Recommendation Report for Planning Permission

REF NO: LU/184/17/PL

LOCATION: Land adjacent to 75A Clun Road
Littlehampton

PROPOSAL: 1 No. dwelling (resubmission following LU/31/14/).

Drawing Number: 2013/14/04

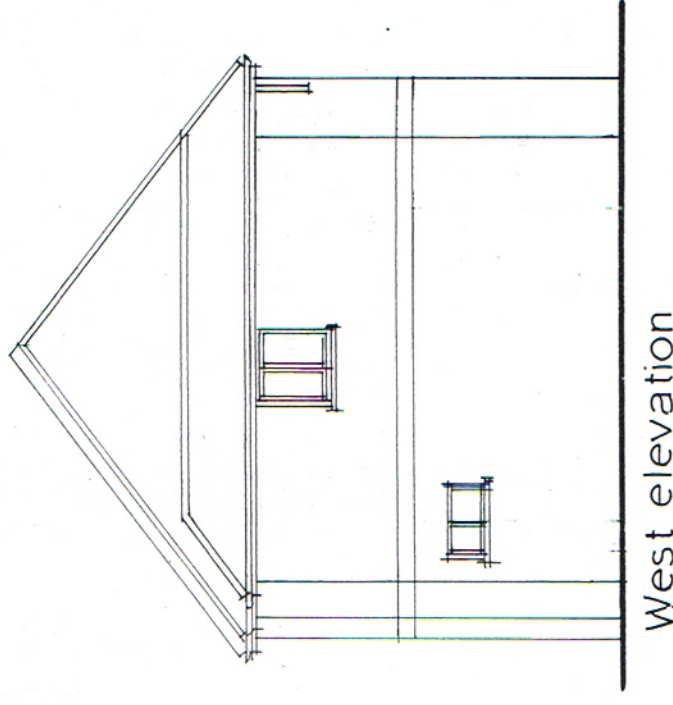
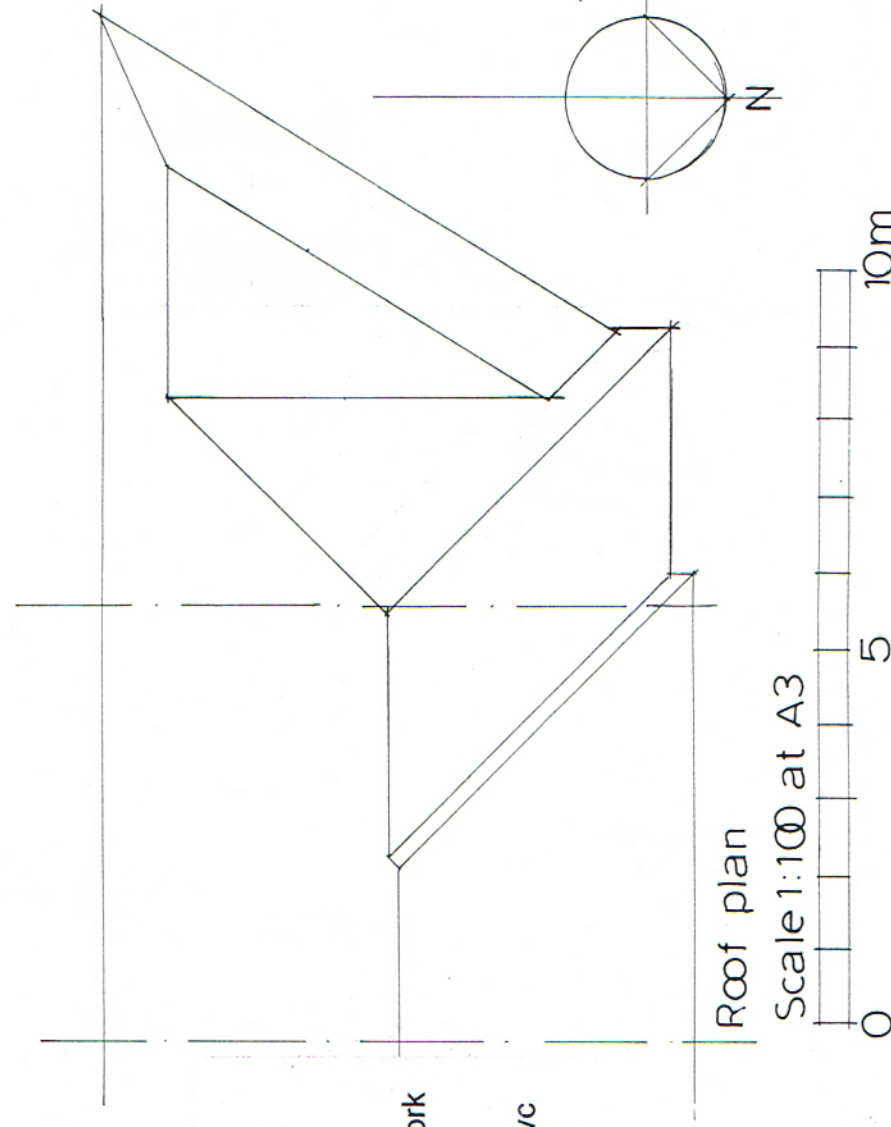
It is considered that this amended scheme by virtue of its design has a detrimental impact upon the character of the locality. The previously approved hipped roof has been extended with the proposed mock pitched roof featuring an extensive flat roof section. By virtue of this, the proposed roof design is considered to have an unacceptably adverse impact upon the spatial pattern and character of the locality. It is considered that the proposed dwelling fails to appear integrated with the existing terrace of properties. It must also be considered that the dwellings in this locality are largely uniform featuring hipped roofs and as such the proposed roof design is considered to appear incongruous within the street scene and out of character with the terrace of properties already present on the site and within the wider locality.

Therefore, the proposed dwelling is considered to conflict with policy GEN7(ii) of the Arun District Local Plan.

Drawing Number: 2013/14/05

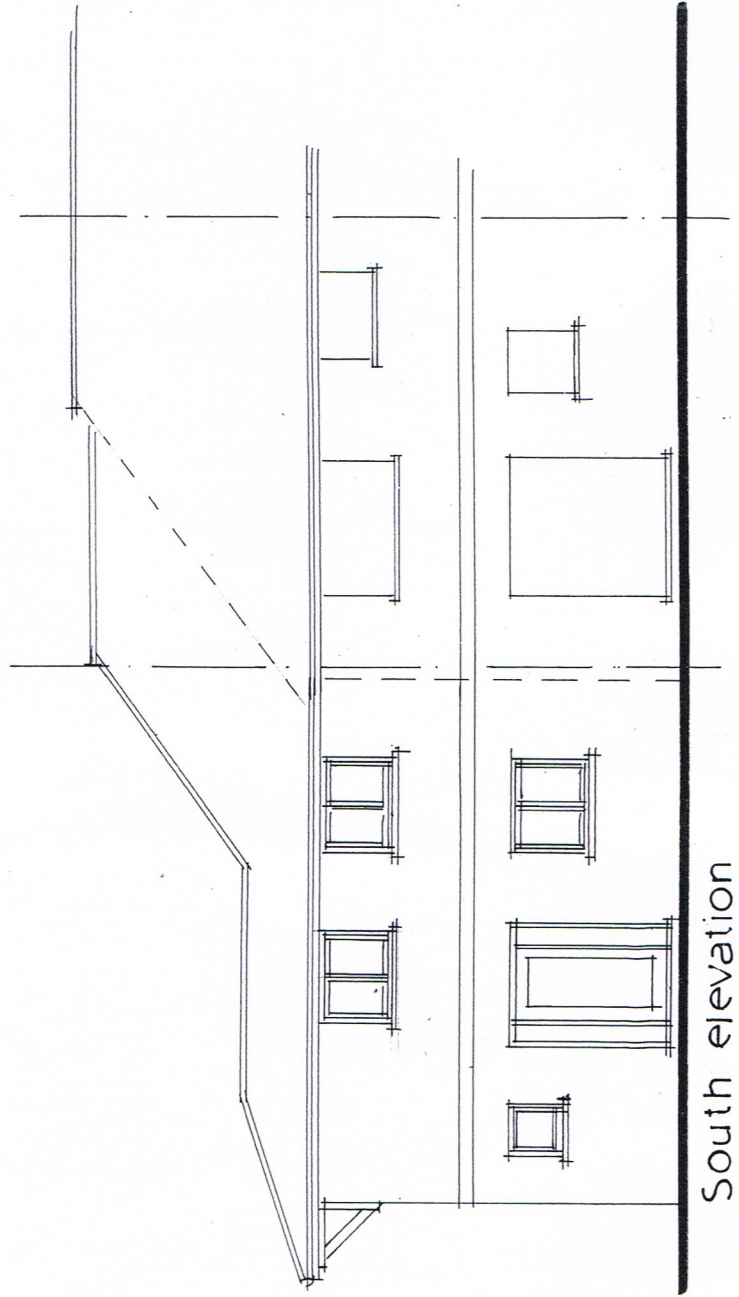
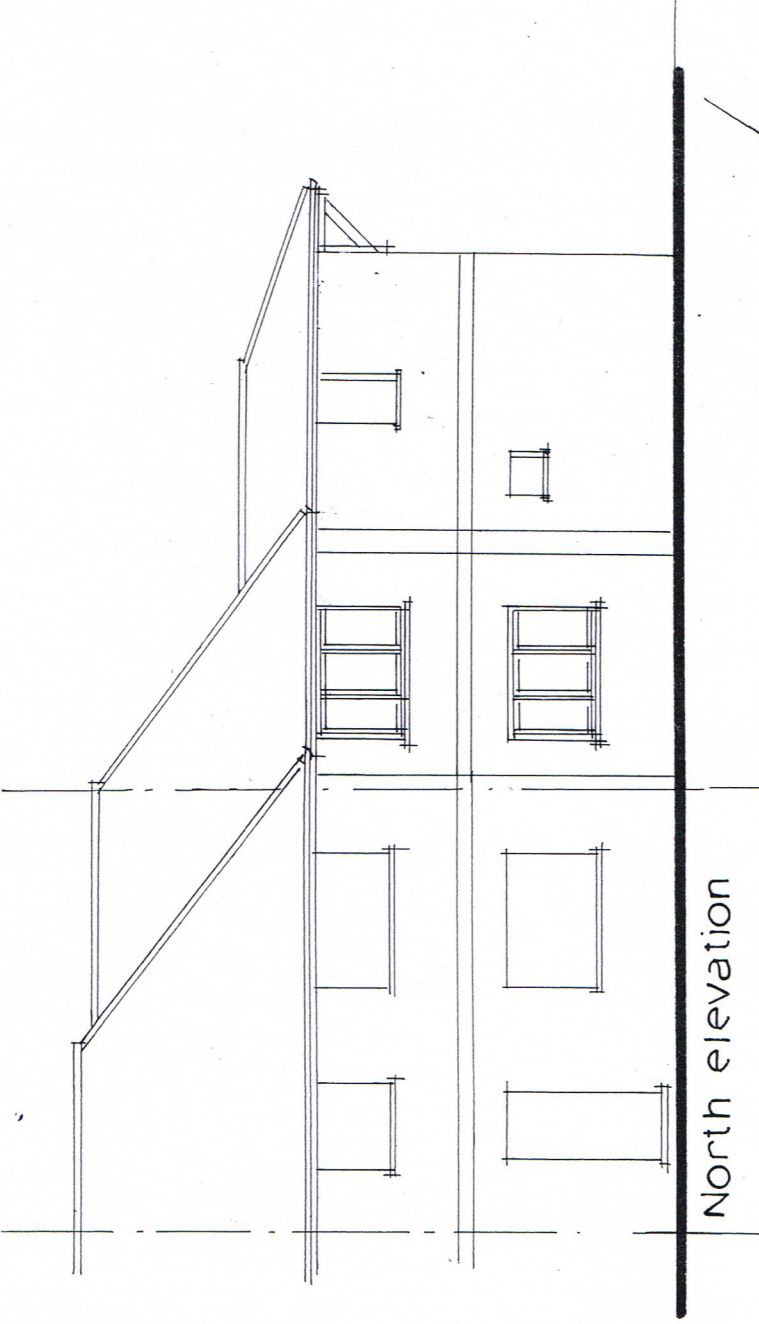
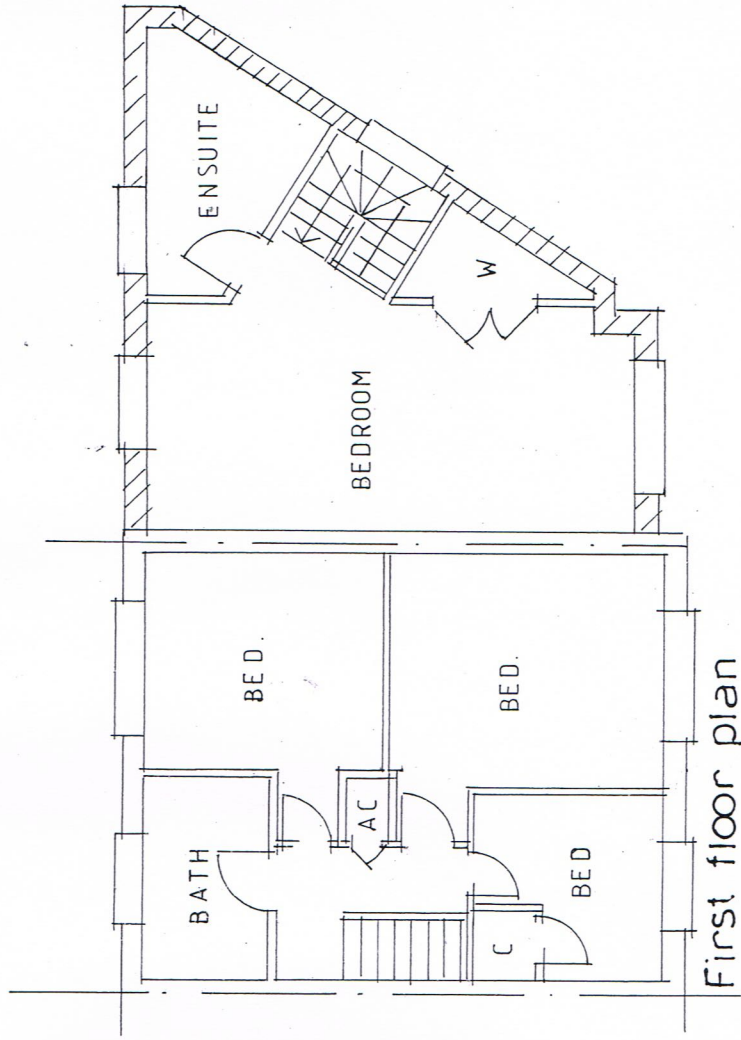
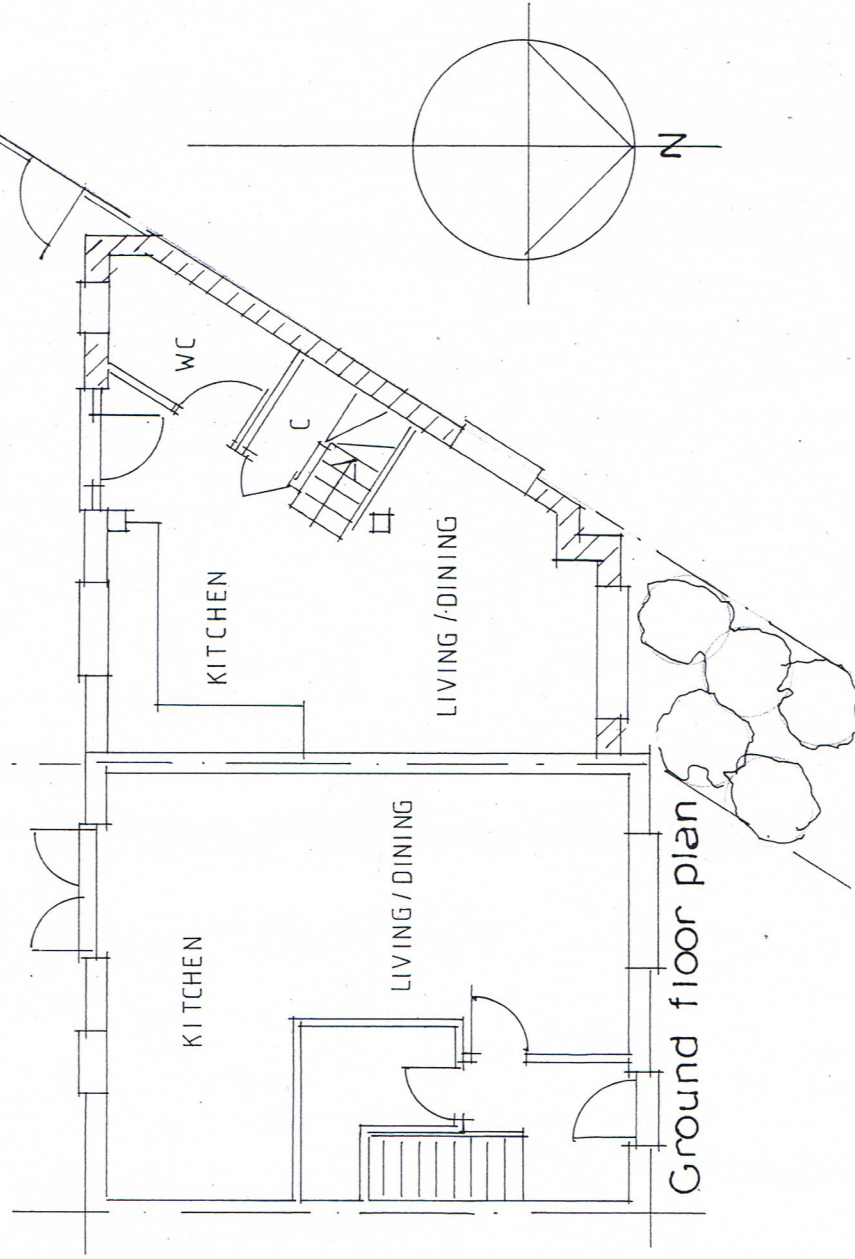
However, it must be considered that the proposal no longer includes a balcony at first floor level and the emerging Local Plan has been through examination although it is yet to be found sound. As such it remains that policy D DM2 can only be given limited weight in the determination of this application. Therefore, it is considered that the proposed outdoor amenity space whilst failing to accord with the requirements of policy D DM2 of the emerging Local Plan does not have an unacceptable impact upon the residential amenity of future occupiers.

The proposed dwelling will have a gross internal floor area of approximately 54m² which exceeds that previously approved under appeal APP/C3810/A/14/2227502. However, since the determination of the previous application the Nationally Described Space Standards (NDSS) were introduced on the 27th March 2015. This sets a minimum space standard of 58m² for a dwelling of this size. Therefore, the proposal fails to accord with the NDSS.
